ENG-PUDSP21010-R3-CDs-Channel.pdf Markup Summary

Comments remain cursory due to the need for the design report, additional grading, complete details and how this ties in to the ultimate subdivision design.

Engineering Review
 04/20/2022 4:17:19 PM
 dsdrice
 JctRisks@engr.com
 (714) 933-7877
 EPC Planning & Community
 Development Department

SHEET NO.
EC1 11

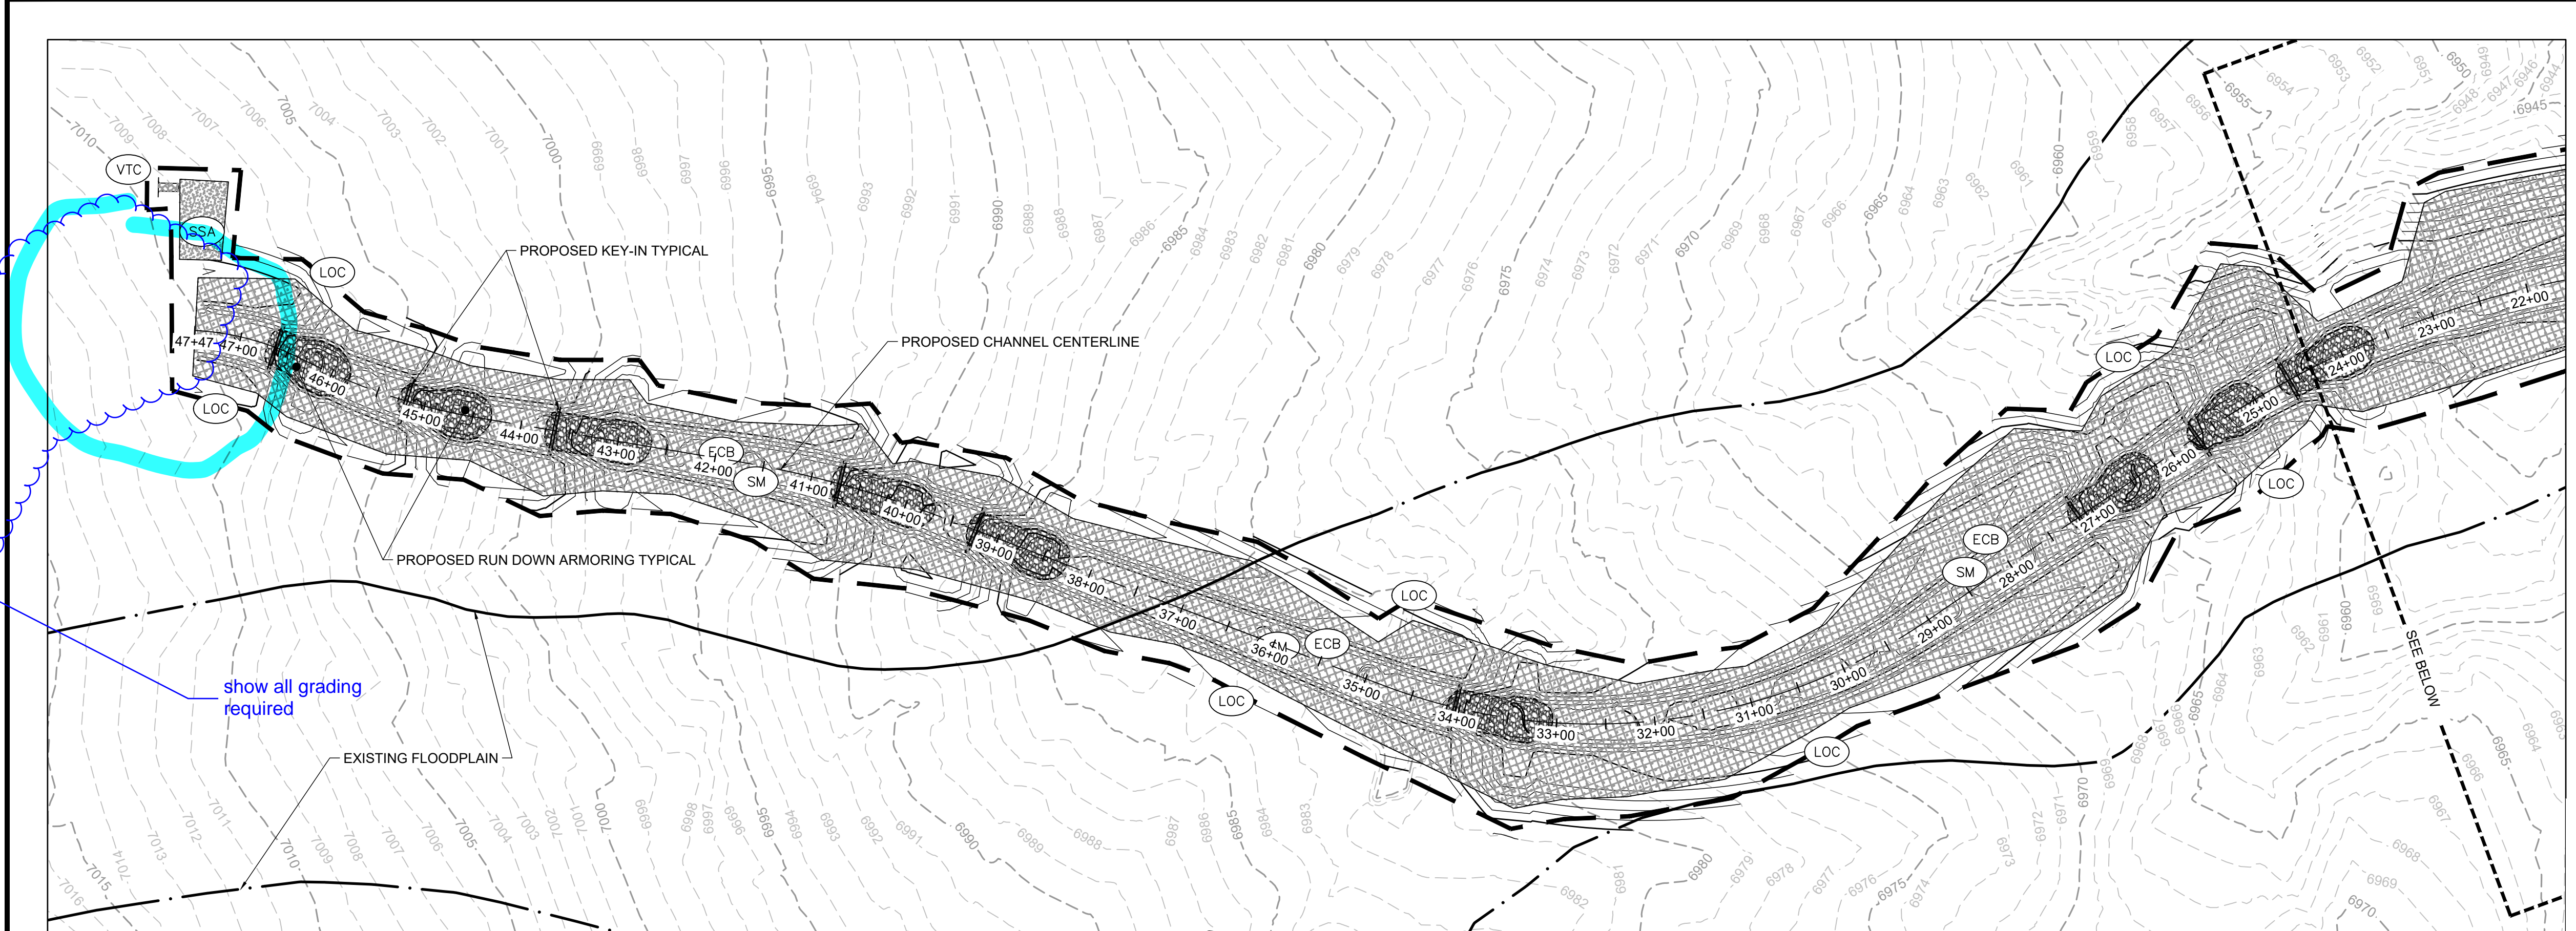
should this be a CD?

Adjust LOC

Show all information required

SHEET NO.
EC2 12

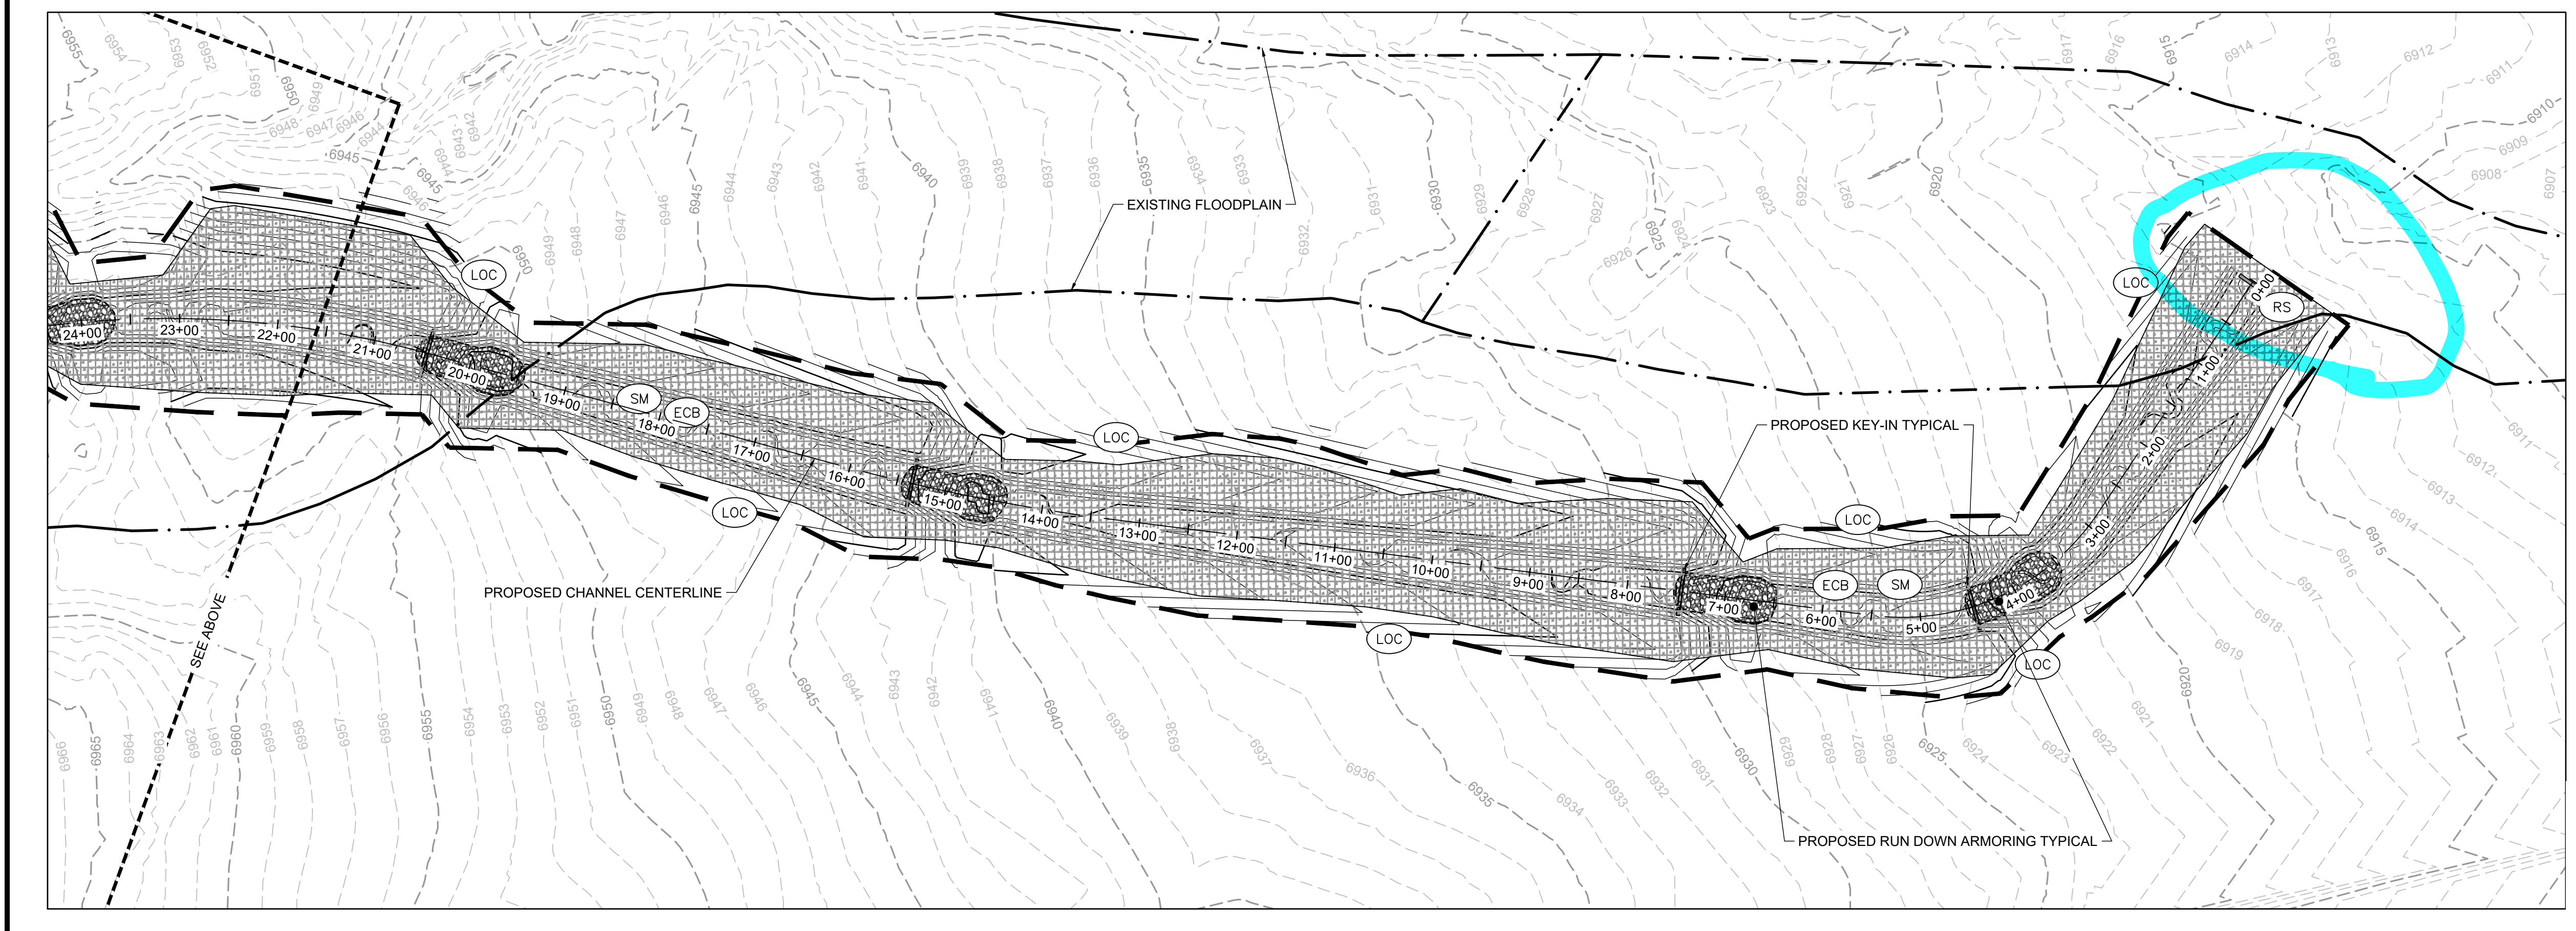
show all grading required

SHEET NO.
PP1 13

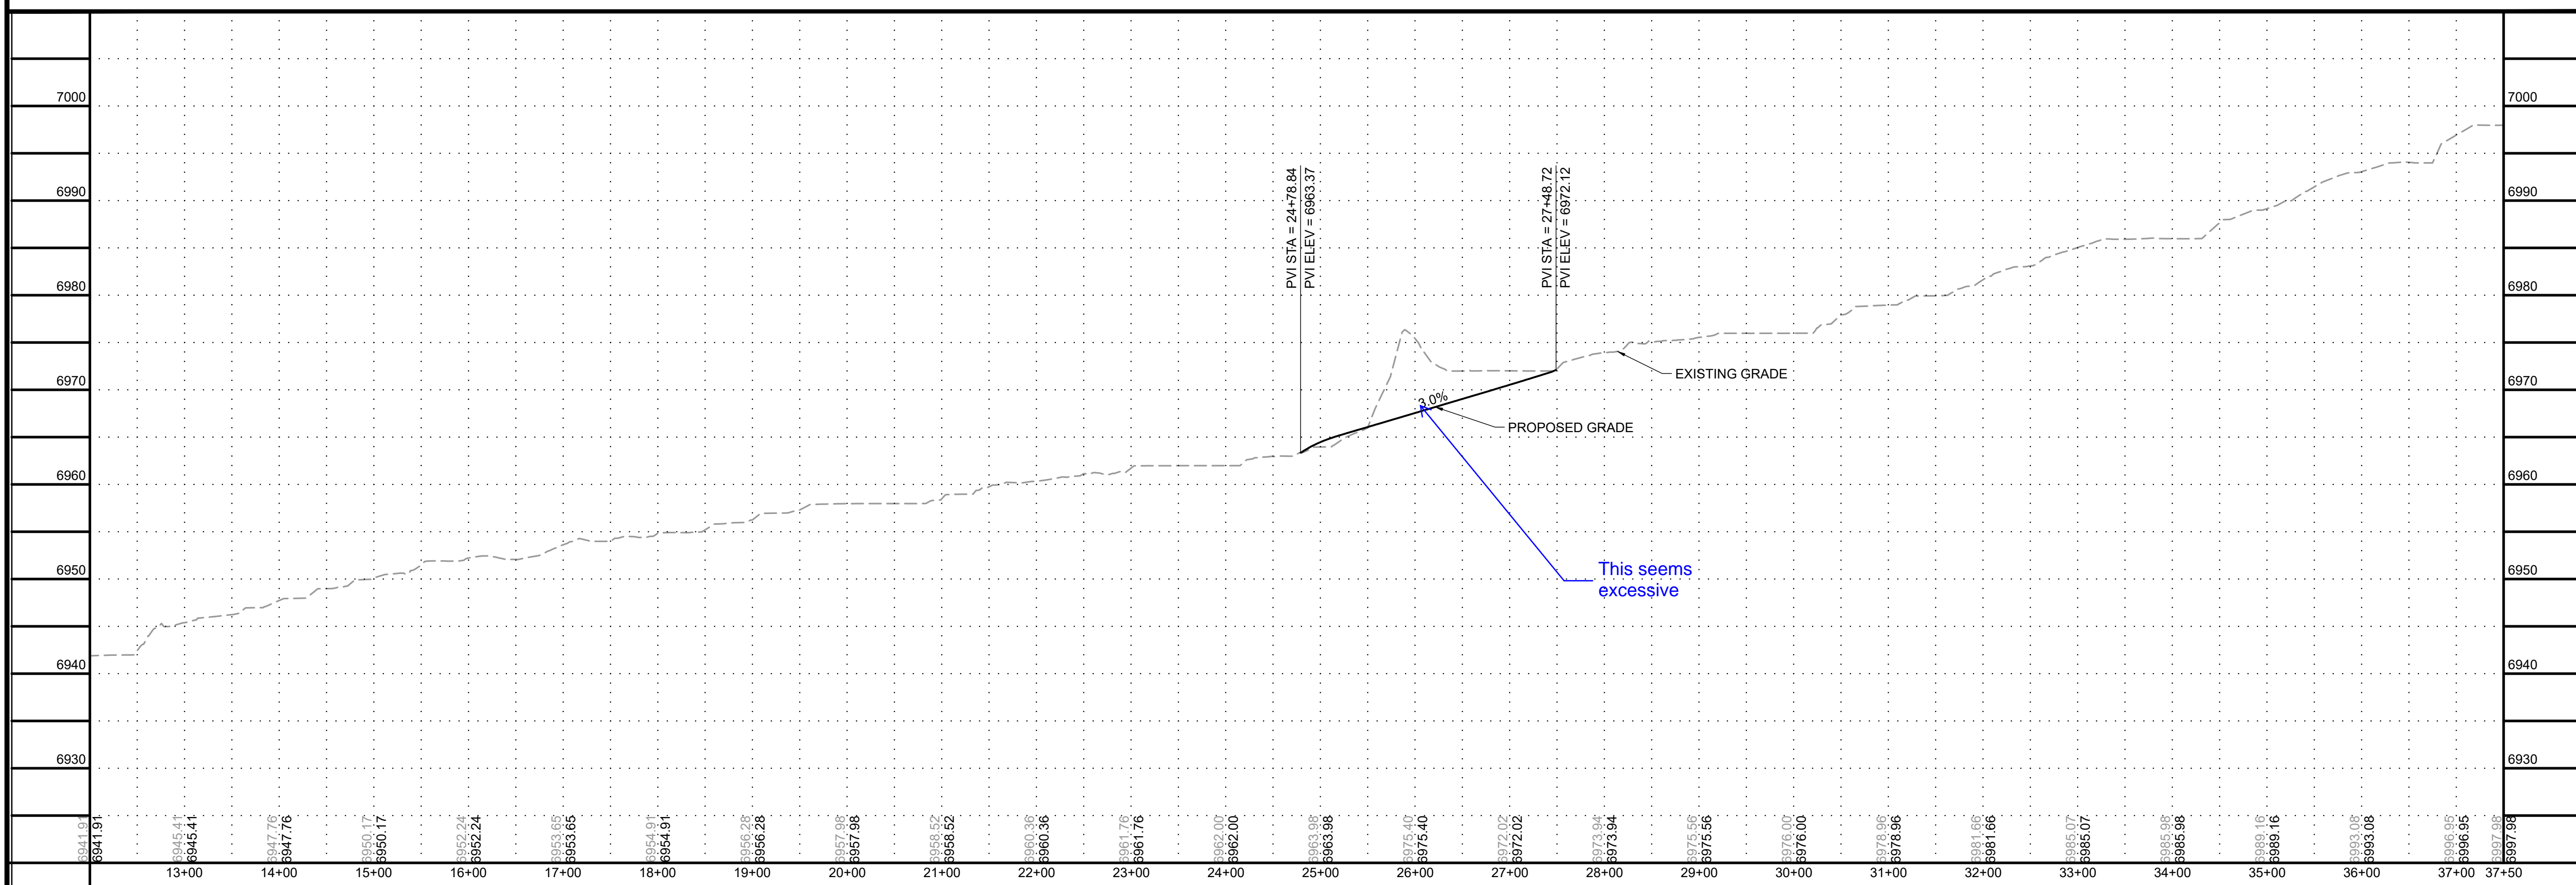
This seems excessive

SHEET NO.
PP2 14

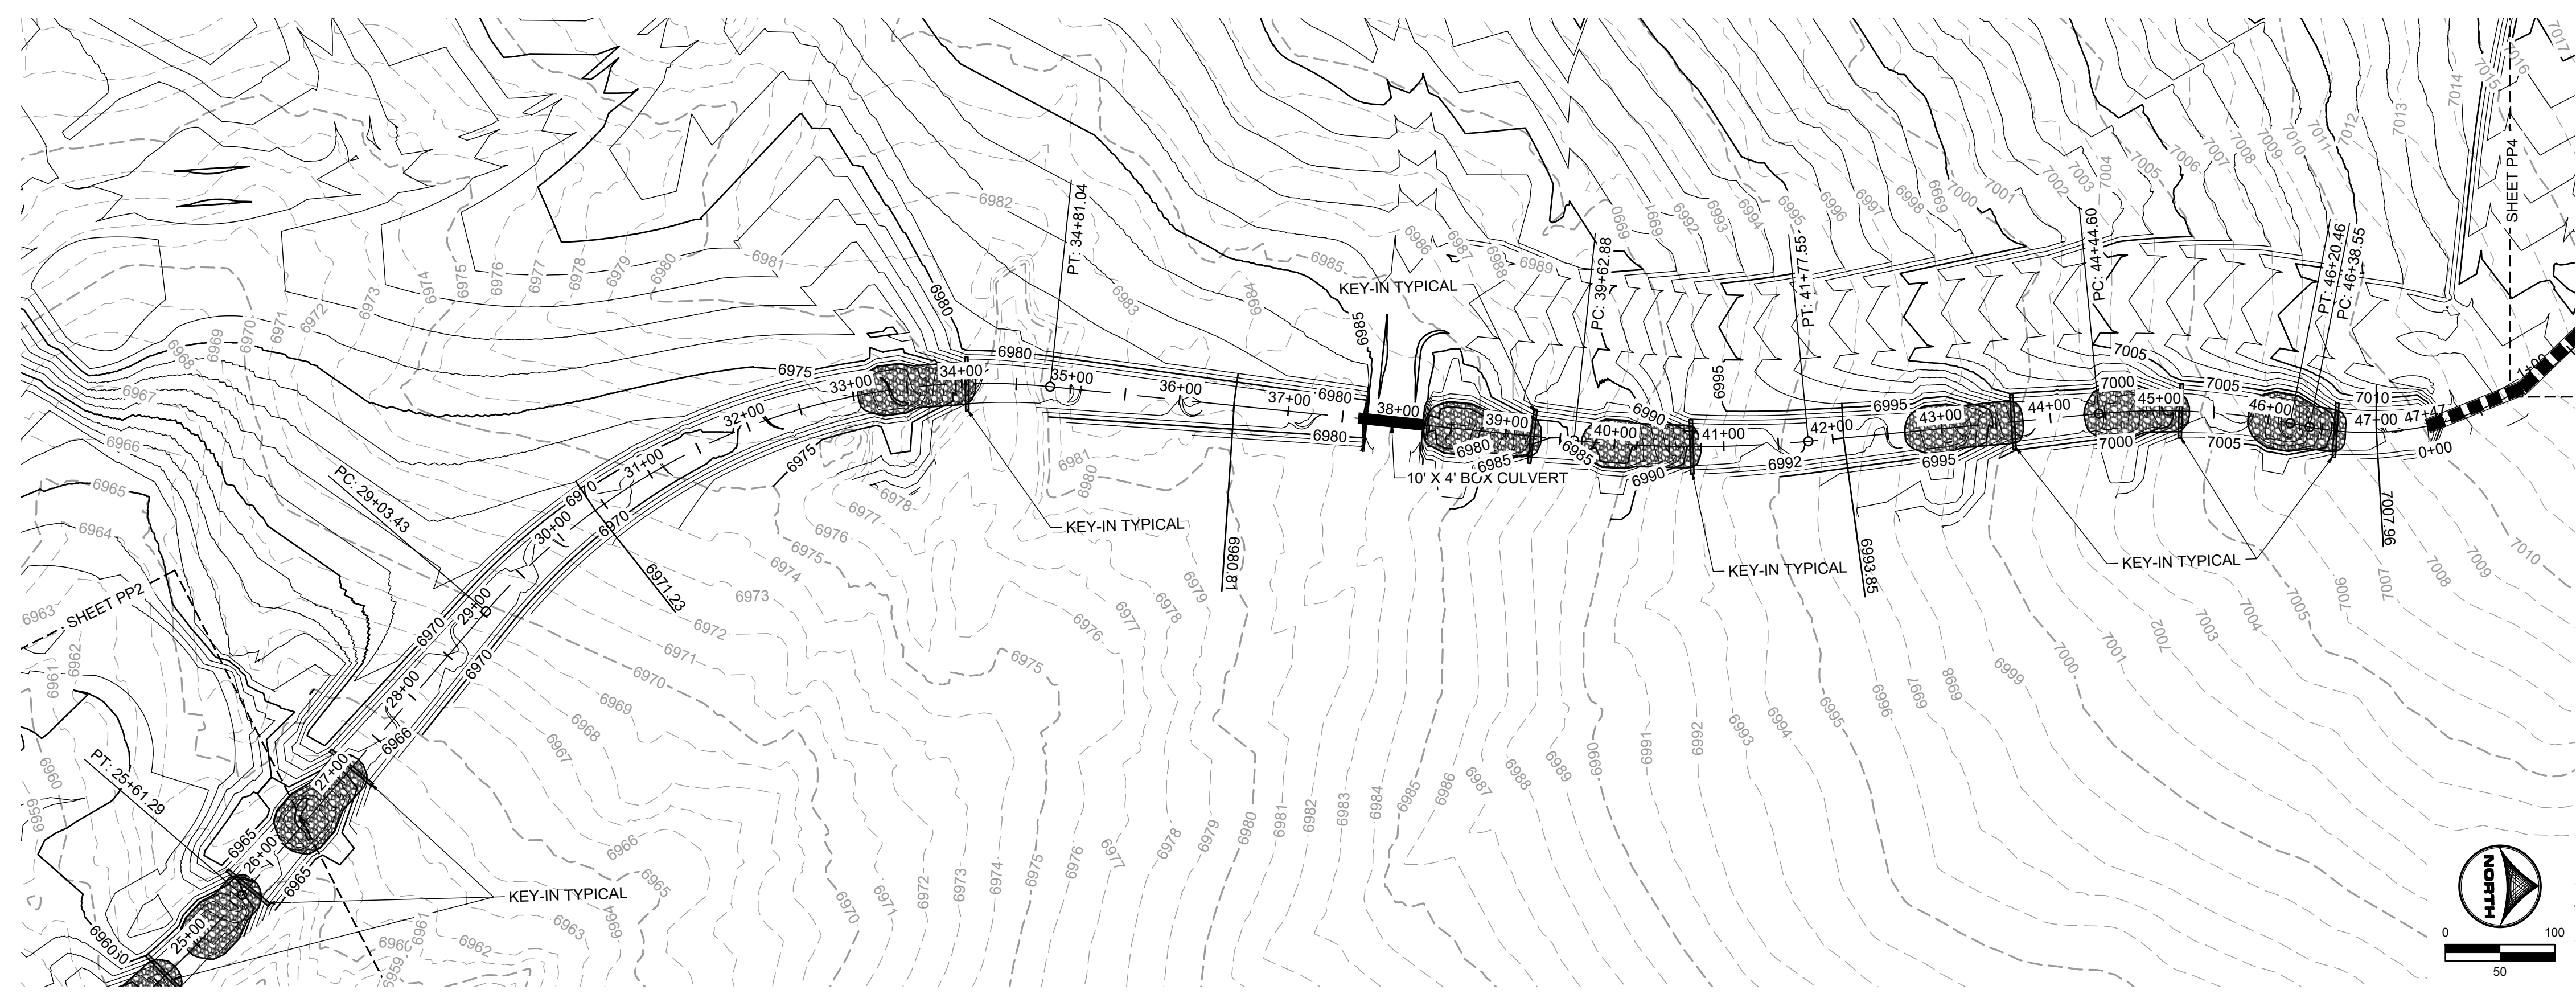
show all necessary grading
